From: [Sanju Reddy](#)
To: patrick.copas@planning.nsw.gov.au
Cc: [Sanju Reddy](#)
Subject: Cor Comments Major Projects – New Request for Advice - (SSD-9741-Mod-3) (Lane Cove)
Date: Monday, 6 March 2023 1:33:27 PM
Attachments: [image001.png](#)
[image289564.png](#)

Council has a concern regarding potential glare caused from the increased building height, to the Magdala Park.

Drawing Title
ELEVATIONS 1

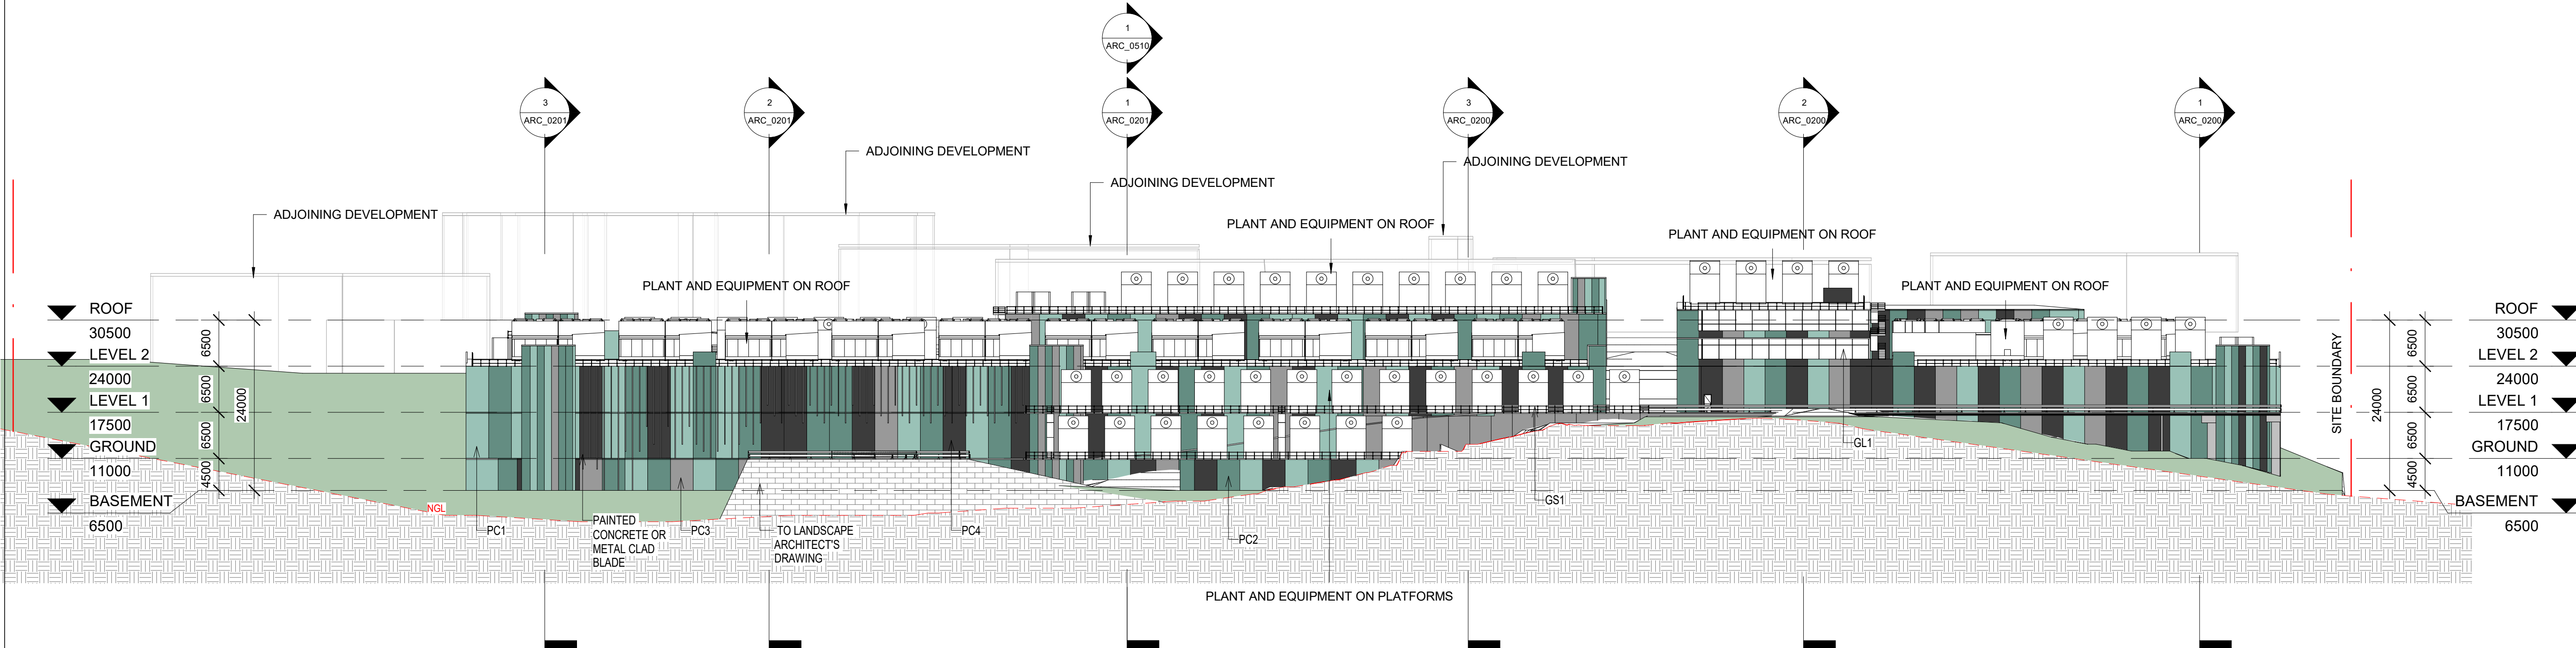
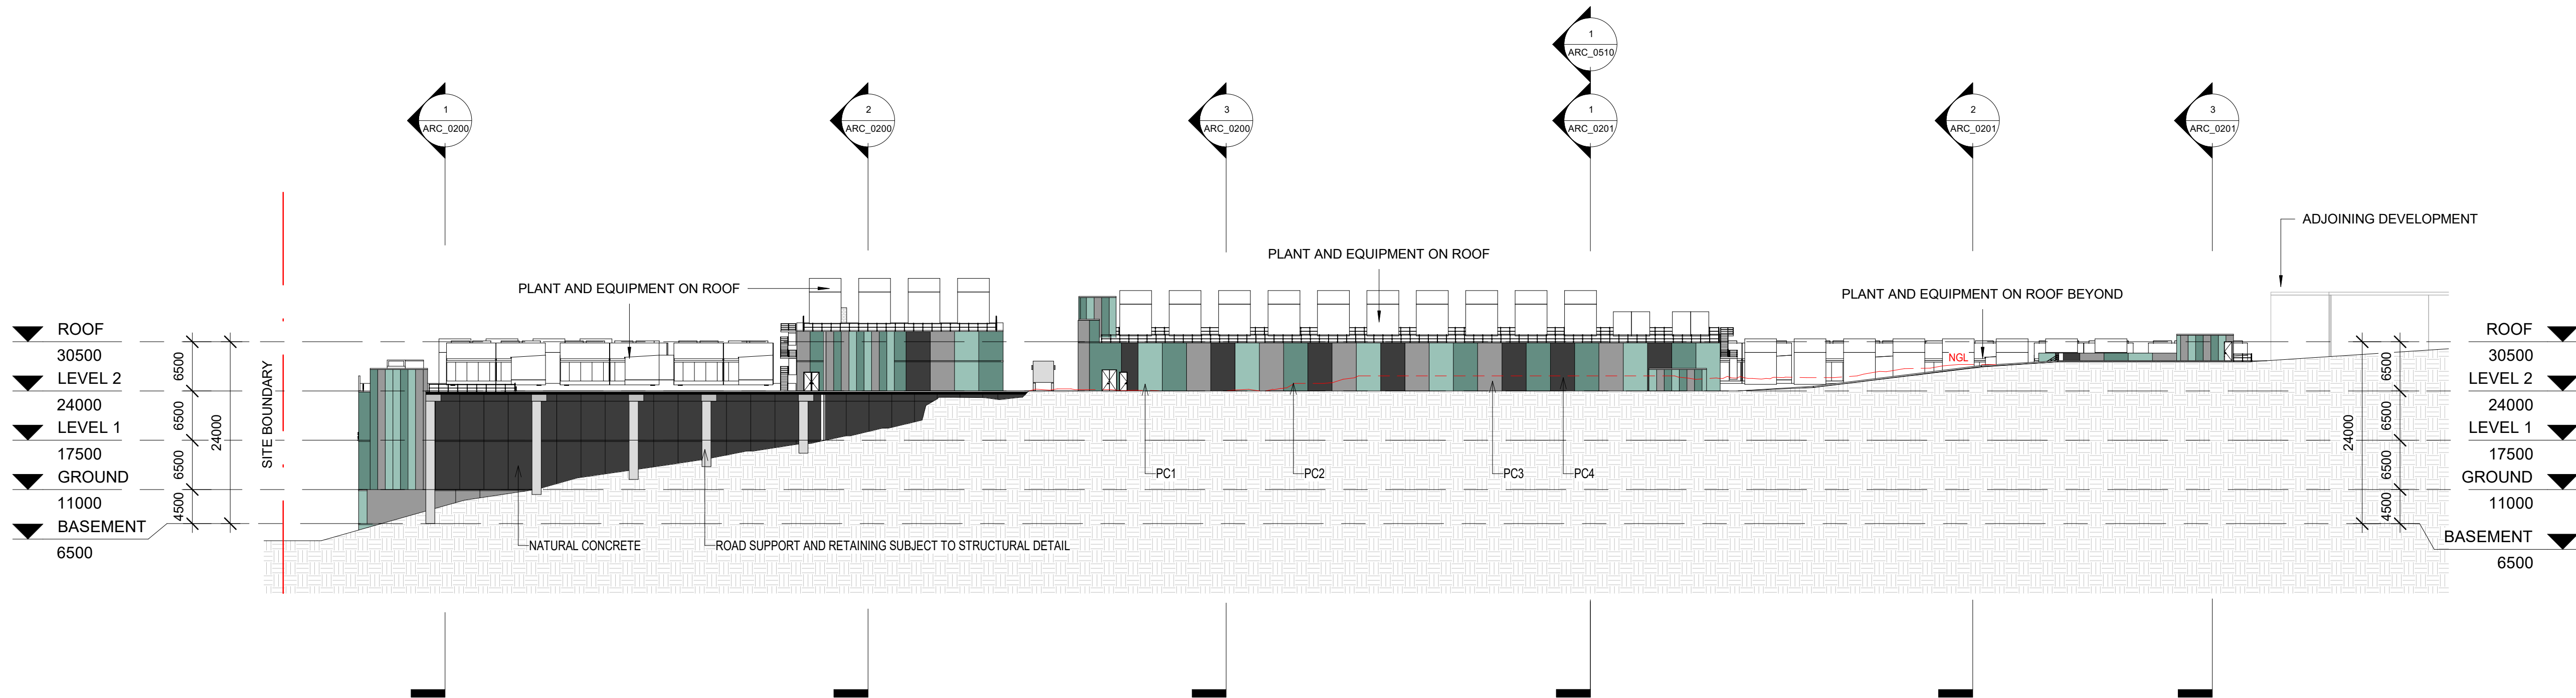
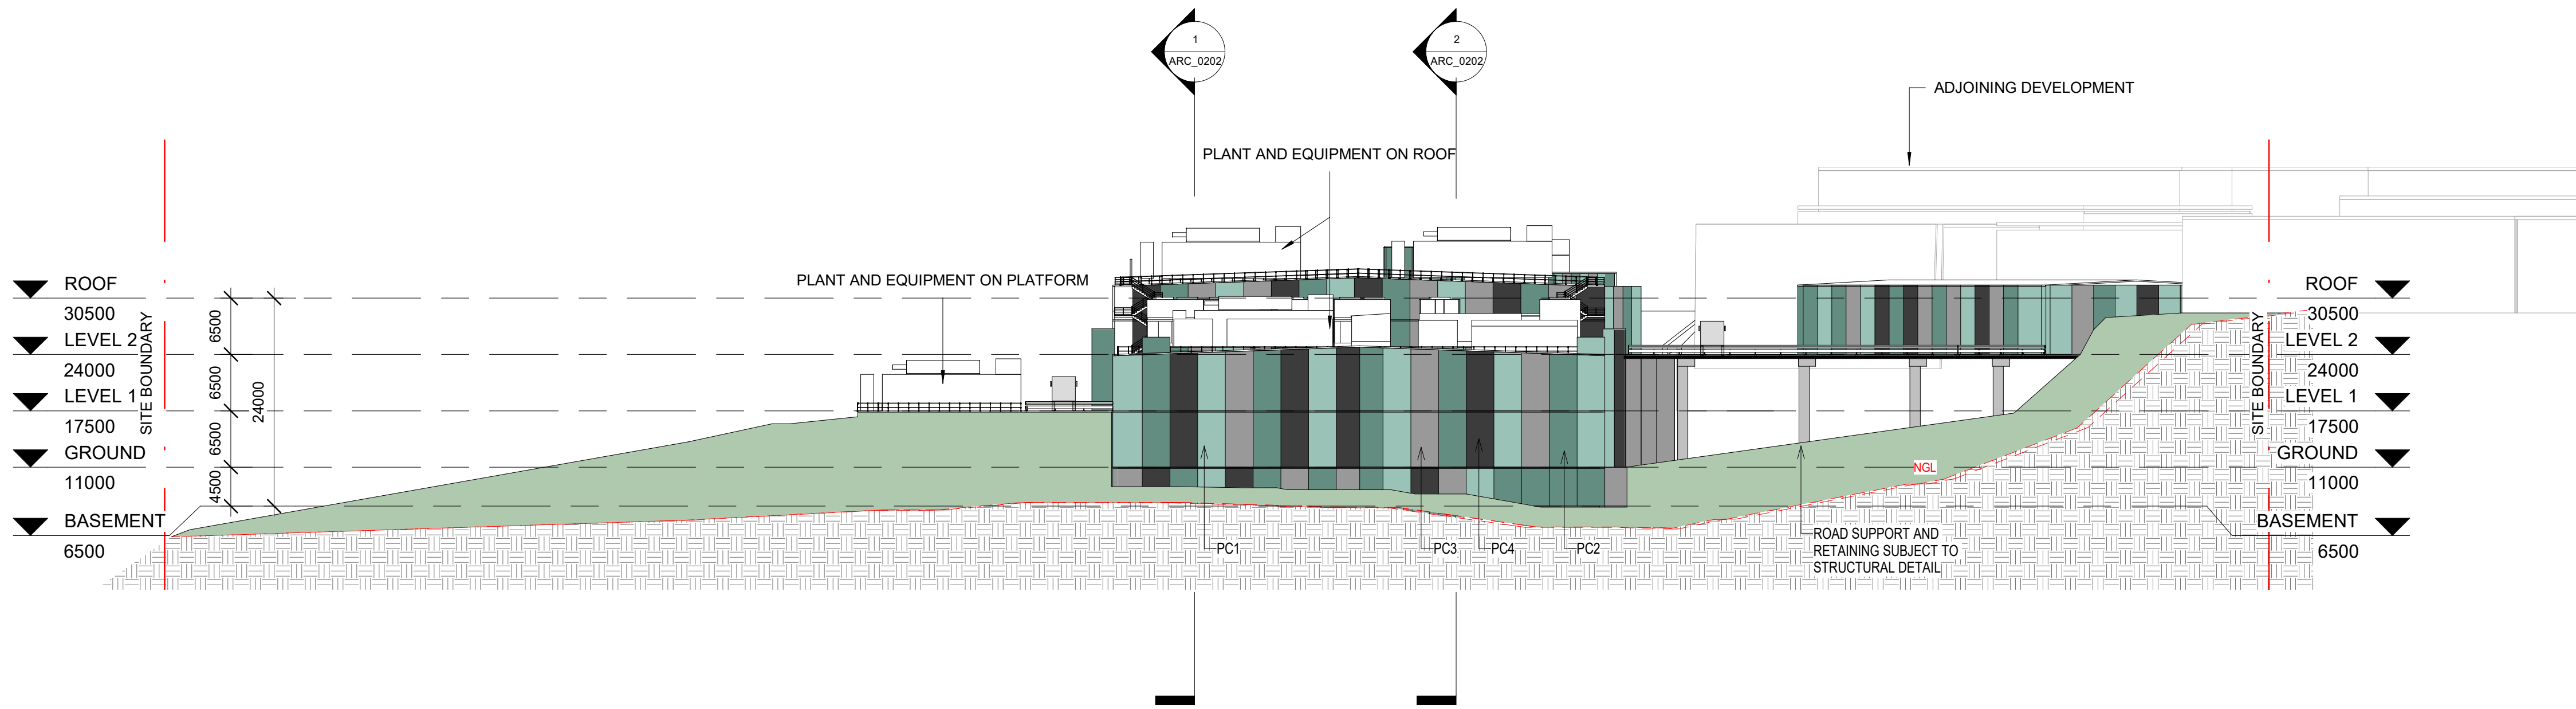
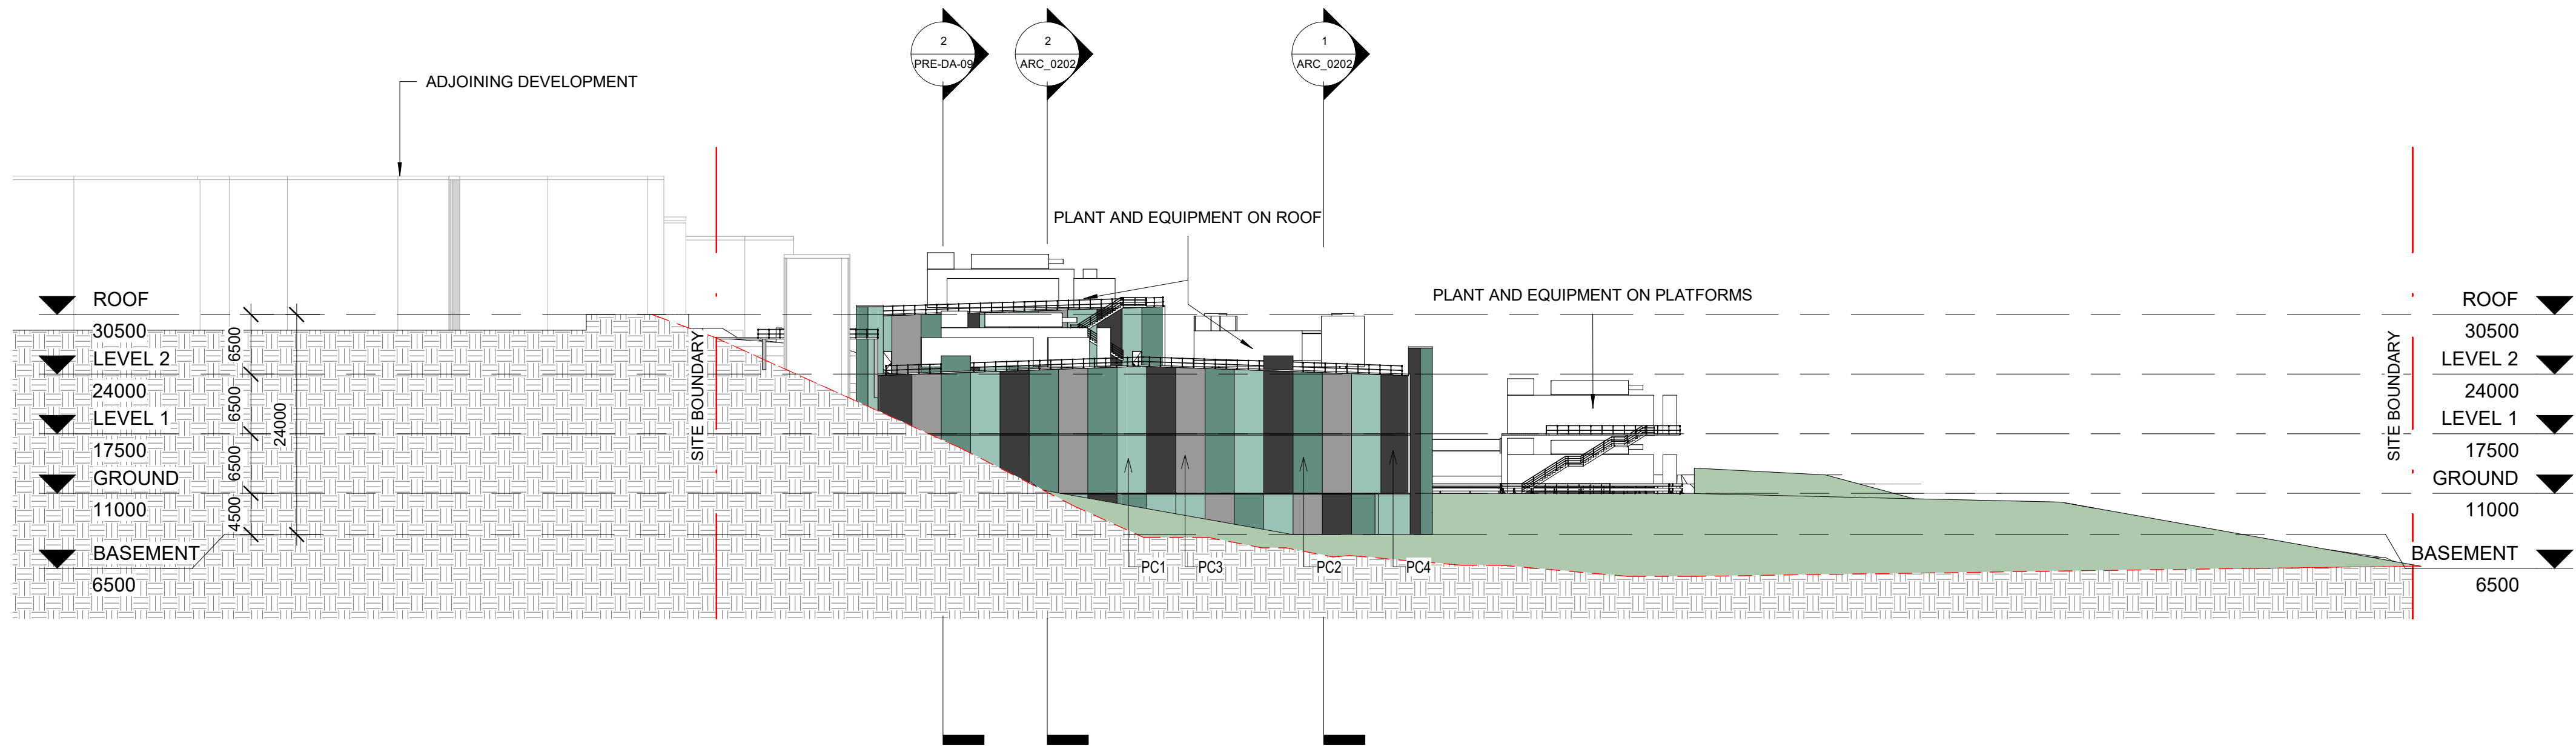
Could you please request that the façade details are provided and kindly ensure that it is non-reflective or not white or reflective material.
